Application by Highways England for M54 to M6 Link Road

The Examining Authority's written questions and requests for information (ExQ1)

Issued on 20 July 2020

Designed	Drawn	Checked	Approved	Date
MW	MW	AM	RR	06/10/20

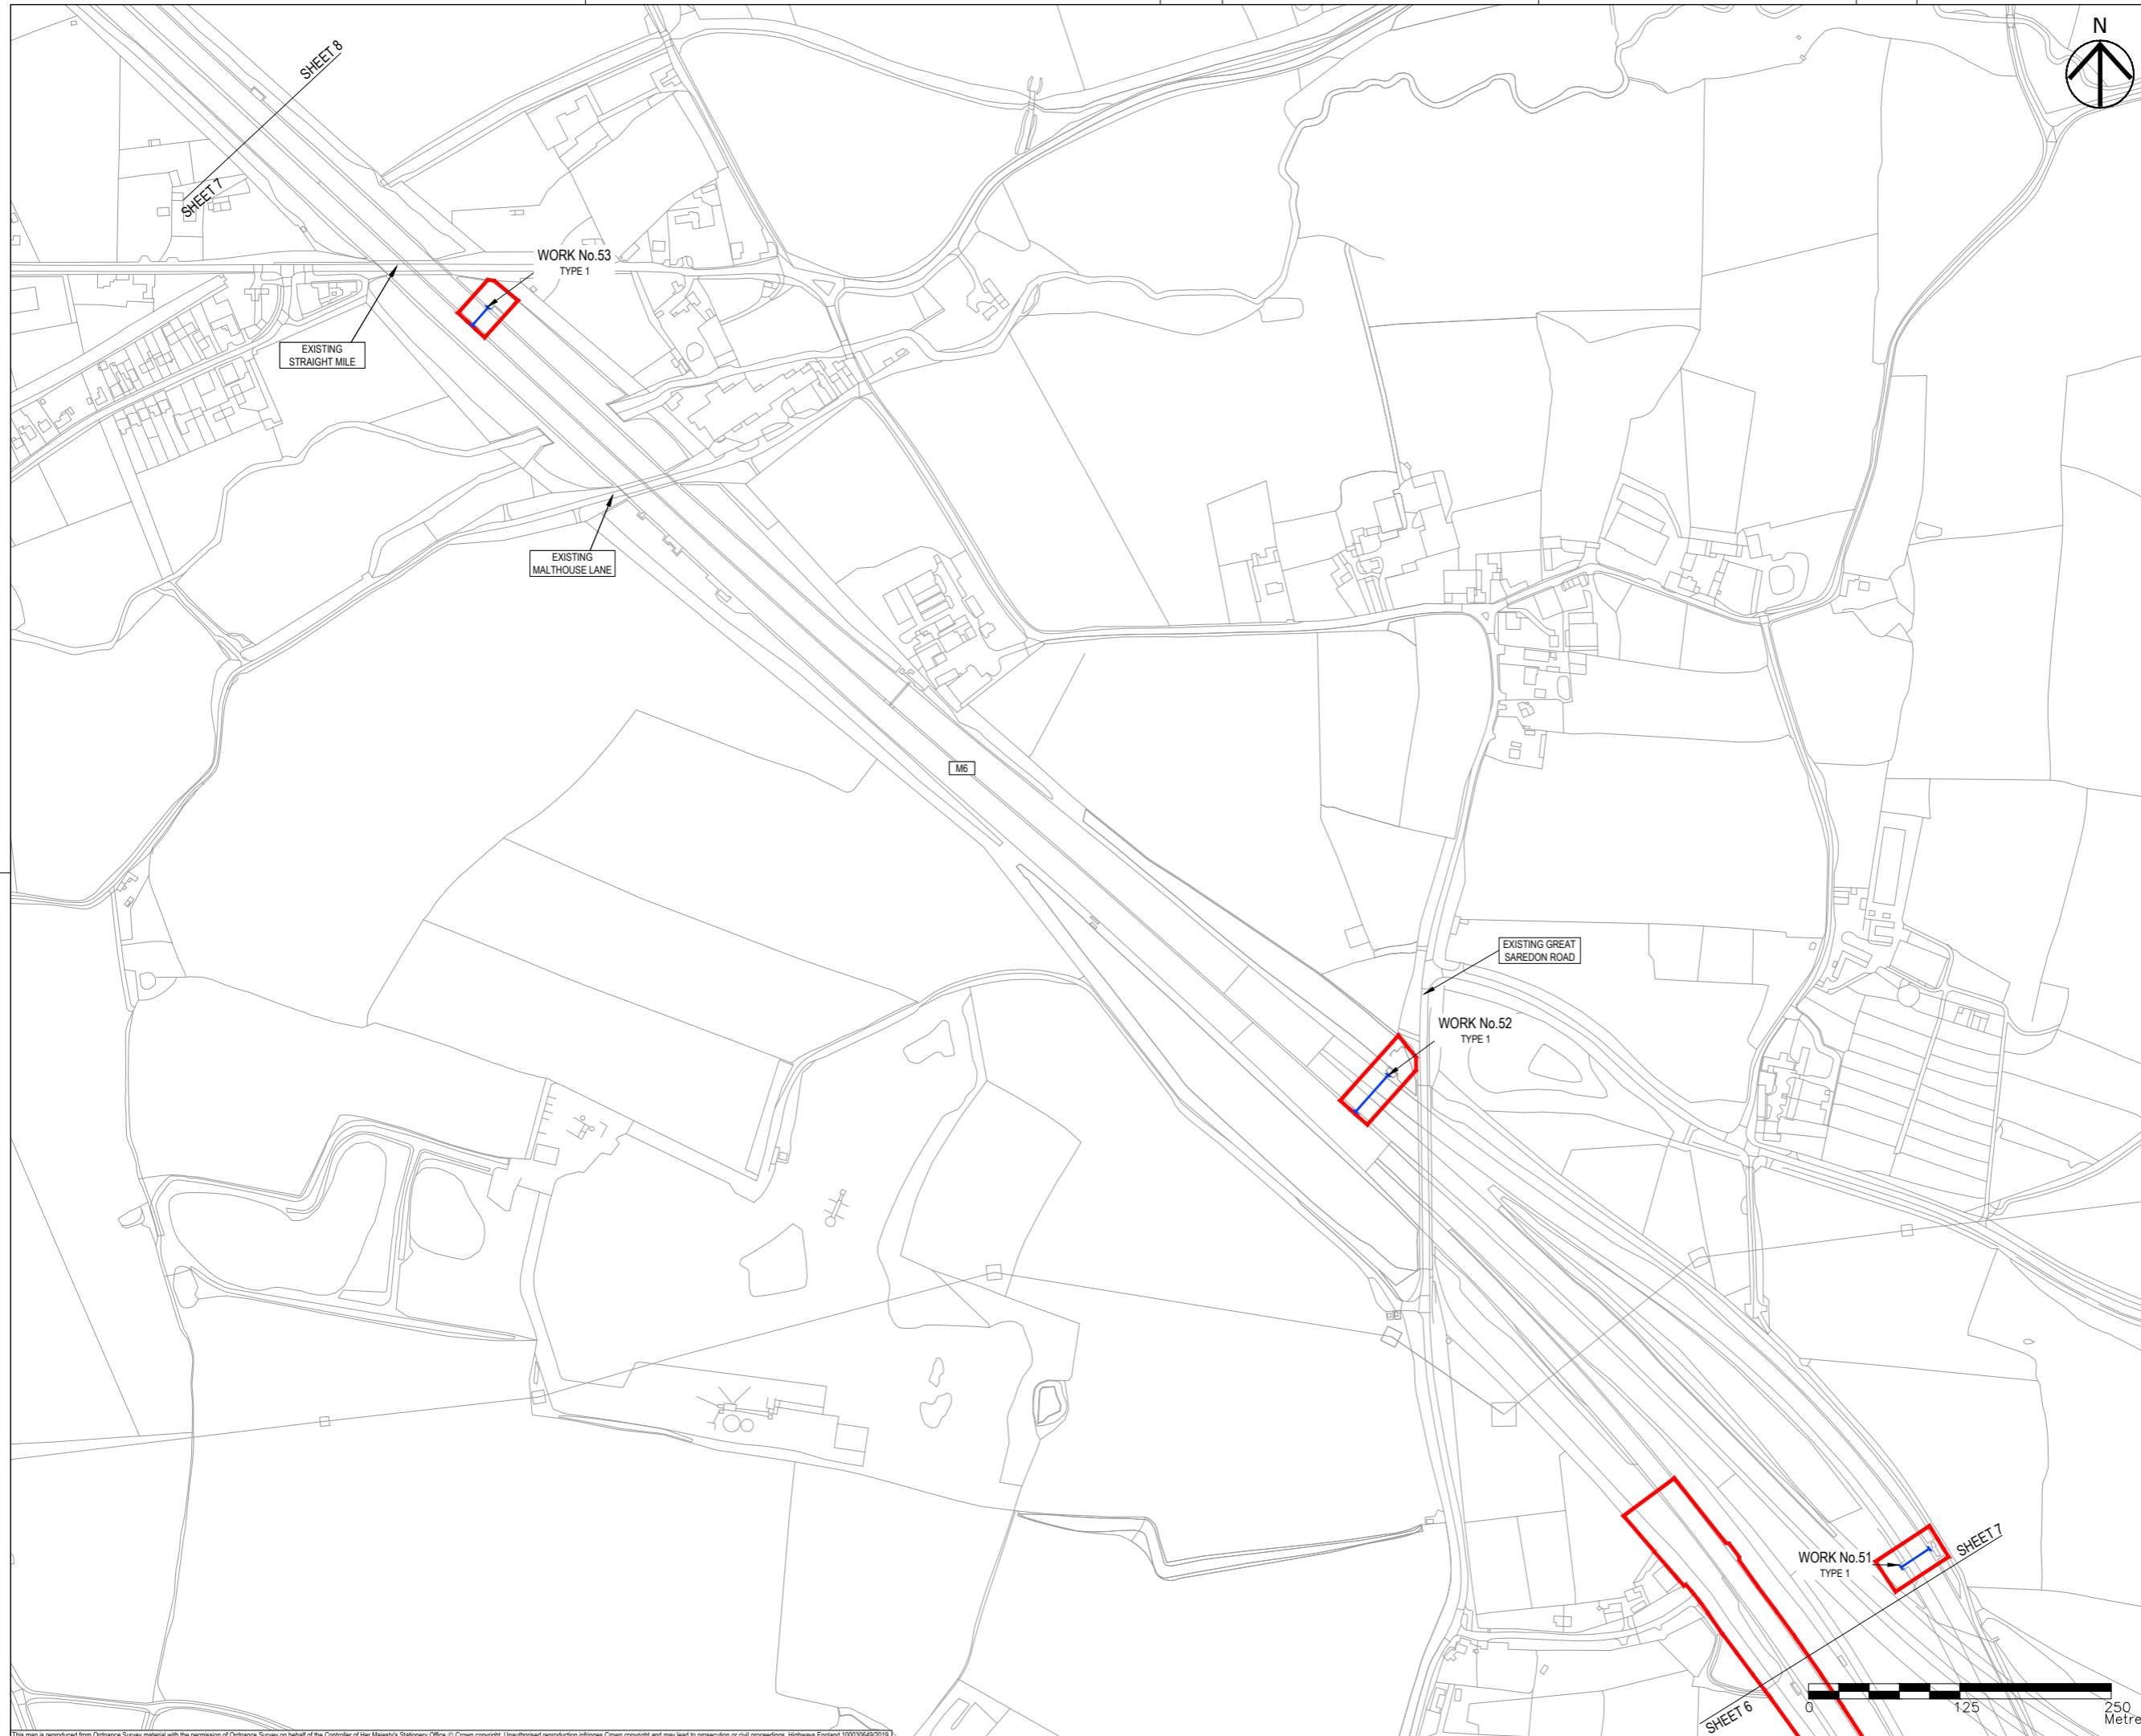
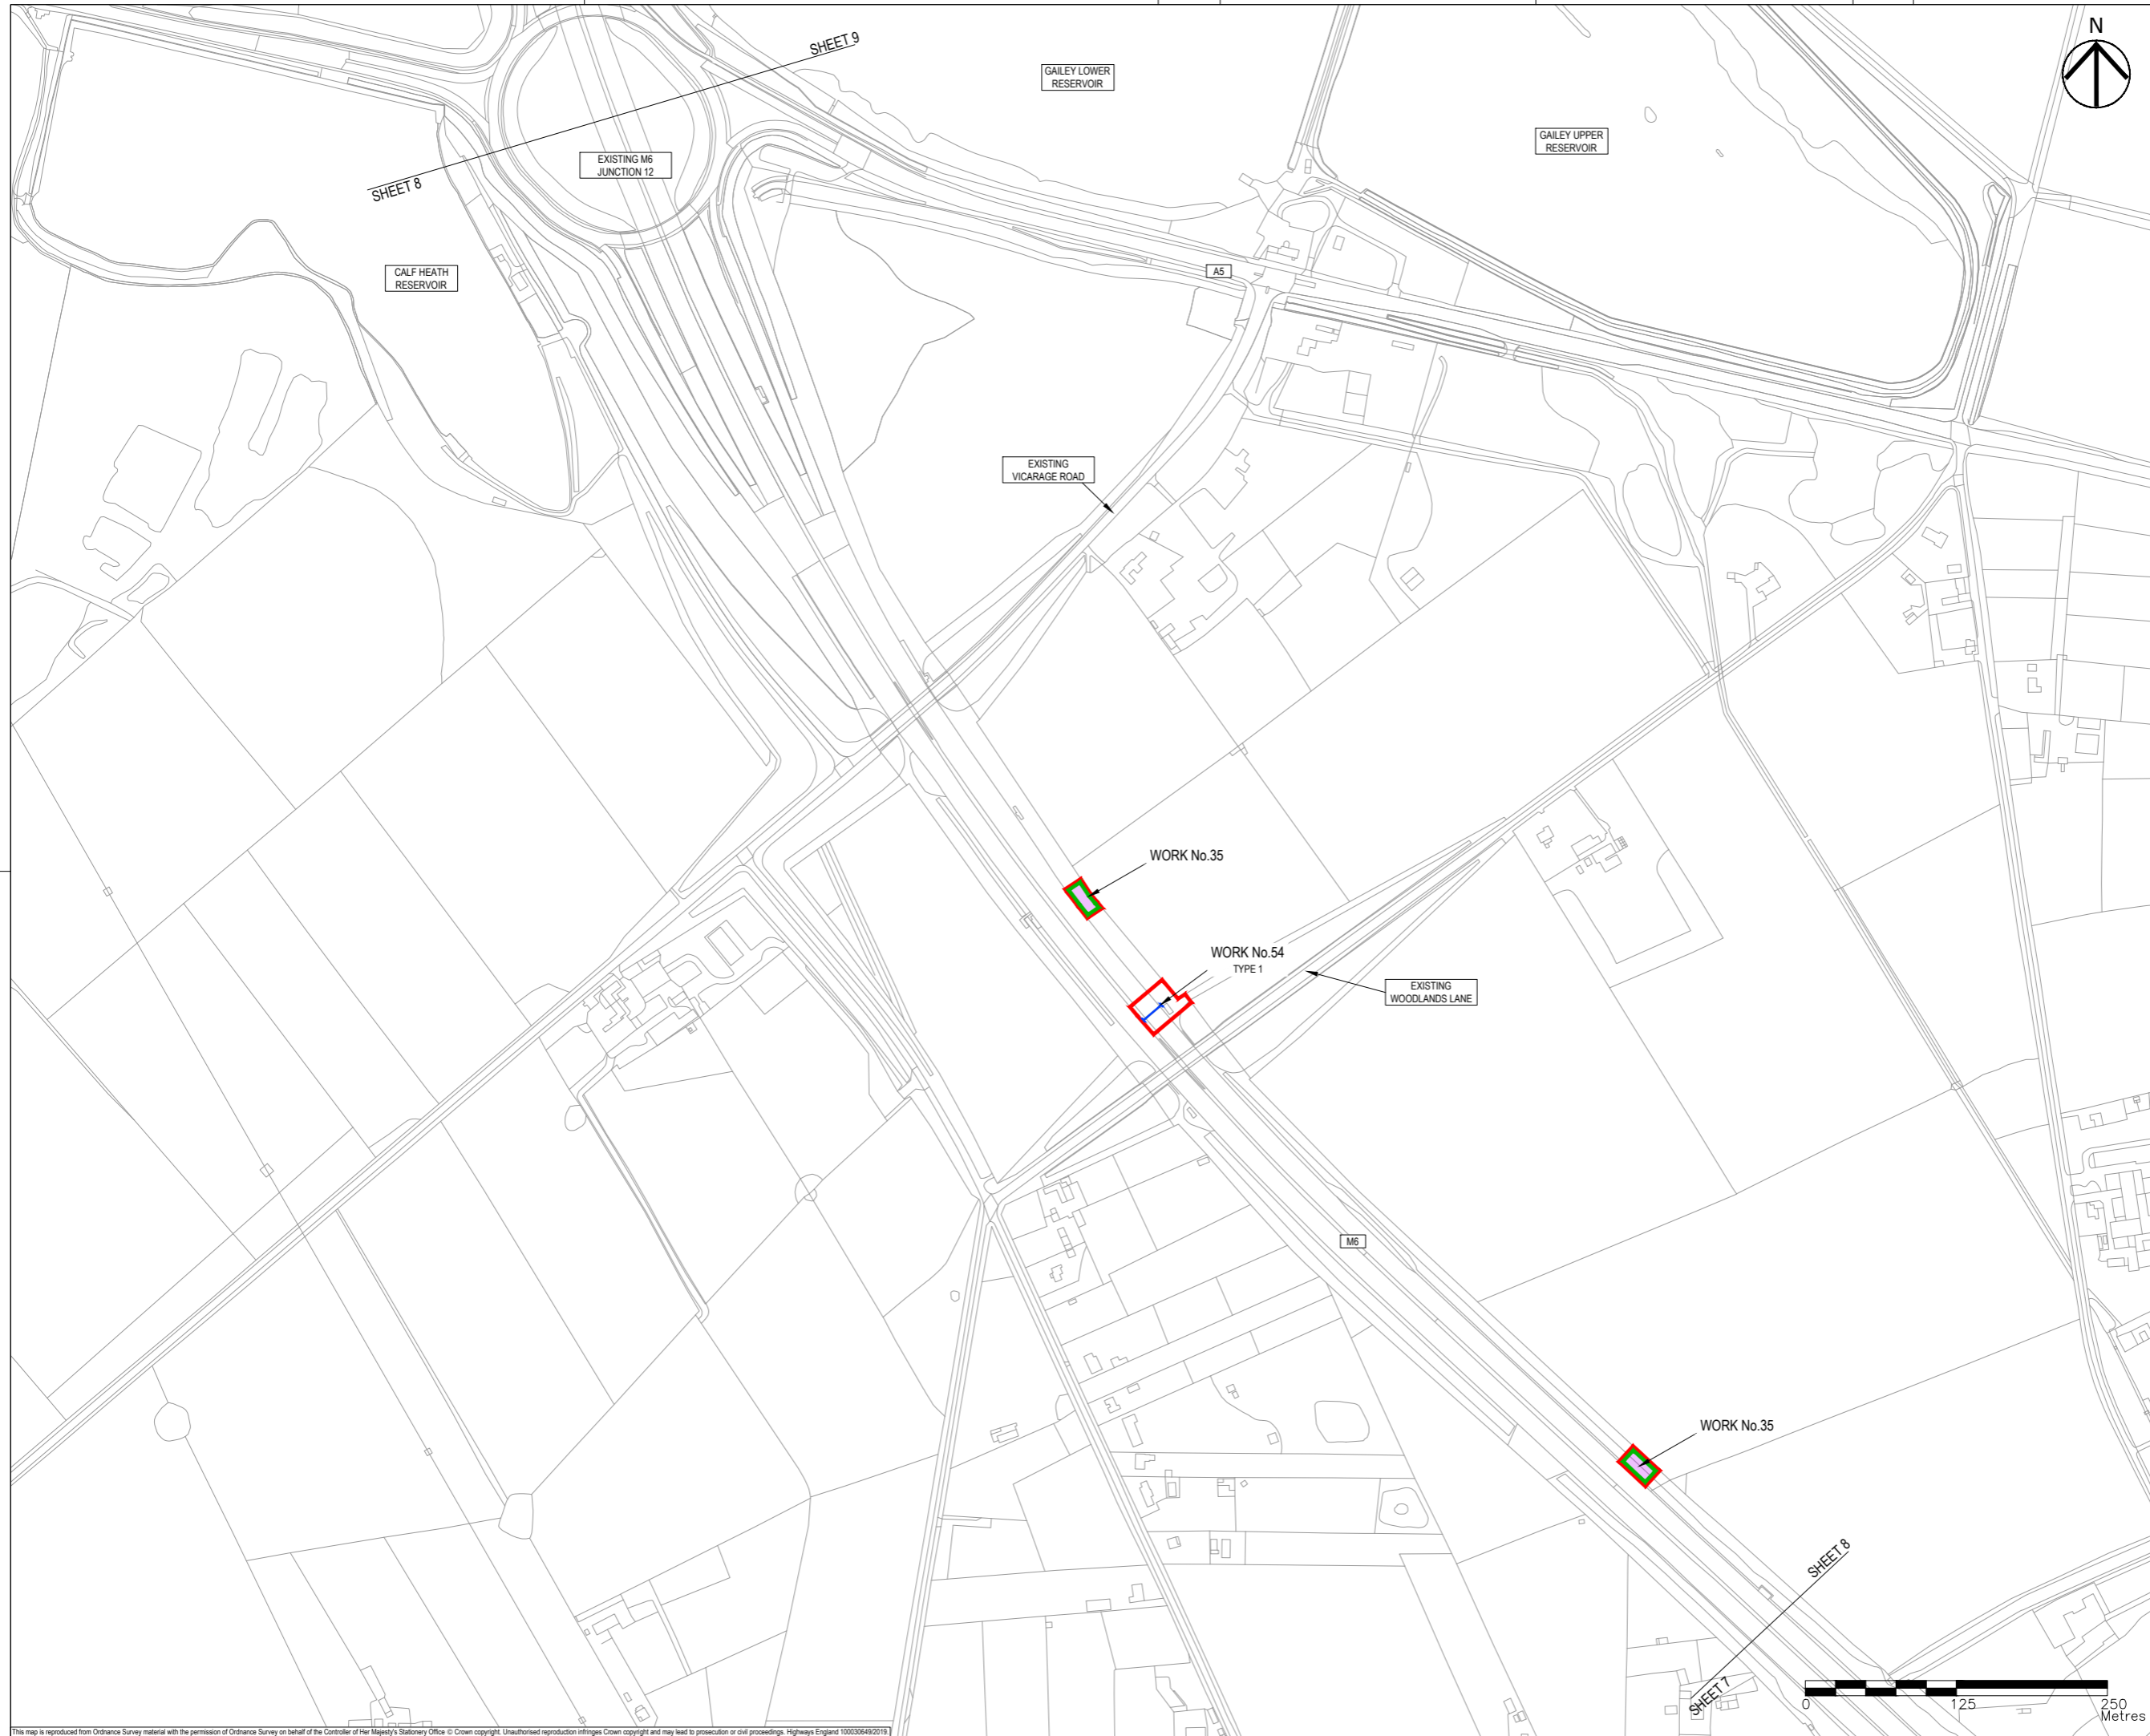
1.0.14	The Applicant	<p>Environmental Masterplan/Works Plans</p> <p>a) Can the Applicant clarify why certain areas of the Proposed Development as represented in the Works Plans red line boundary (within Sheets 1-3, and 6-10</p>

ExQ1	Question to:	Question:
		<p>[APP-057] to [APP-063], which include Works 1, 35, 41, 42, 51, 52, 53, 54, 55, 55A, 55B, and 55C) have not been fully represented in the Environmental Masterplan or in the Construction Works (ES Figure 2.9, [APP-065]) for the ES.</p> <p>b) Can the Applicant explain why these works are not represented on the Environmental Masterplan and the Construction Works plans and confirm that these works have been fully considered as part of the ES.</p>
